CITY OF PORTLAND, MAINE  
 DEVELOPMENT REVIEW APPLICATION  
 PLANNING DEPARTMENT PROCESSING FORM

166 - 166 Lambert St, Portland, Maine

<b>TO: JAY REYNOLDS</b>	<b>DATE: 07/19/05</b>
	<b>JOB No.: 27950.1</b>
	<b>FROM: GREG BOULETTE</b>
<b>RE: 166 LAMBERT STREET</b>

**From:** Jay Reynolds  
**To:** Greg Boulette  
**Date:** 07/14/2005 10:52:51 AM  
**Subject:** Lambert Street Application

Revised / approved site plan

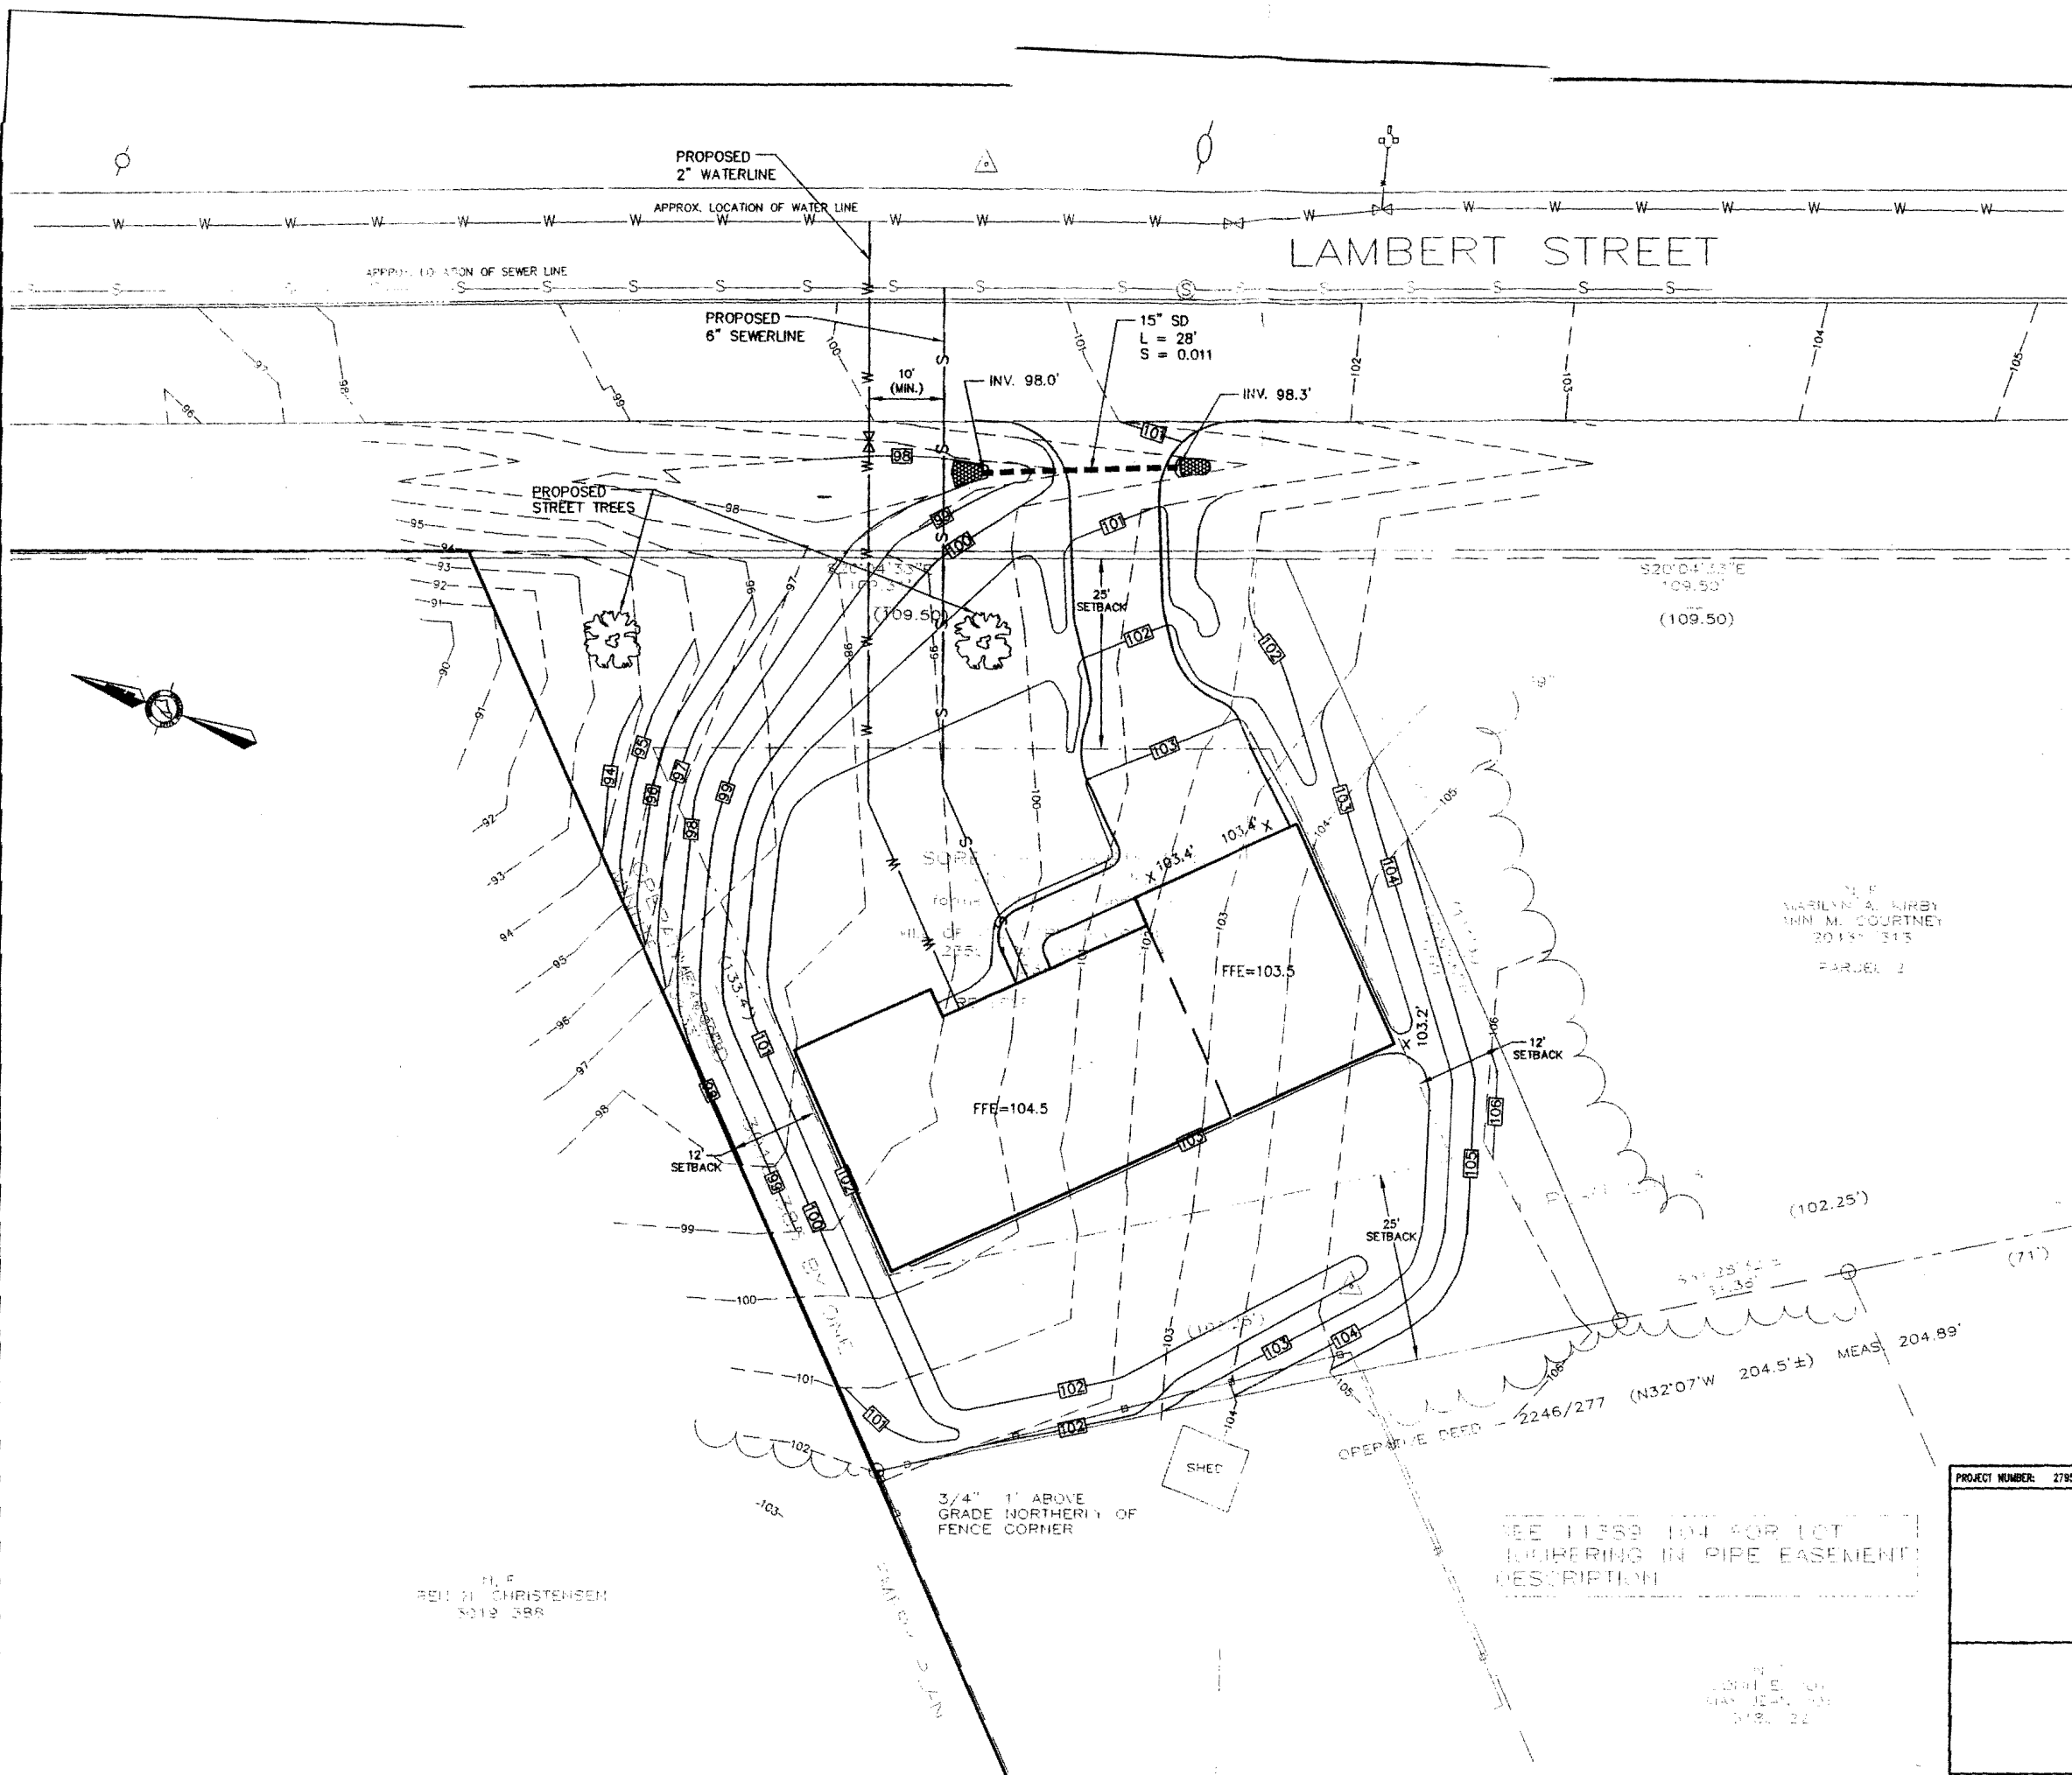
1. Please re-contour the northerly side line to that drainage is directed toward Lambert Street more.
2. Add silt fence along the northerly side line as appropriate.
3. A boundary survey/stamp should be included as part (code will require this), thus, remove note 4.
4. Due to the depth and location of the driveway culvert, it shall be reinforced concrete pipe. Please note this on the plan.
5. Add sewer cleanout to the sewer lead (required on leads further than 80' from sewer main).
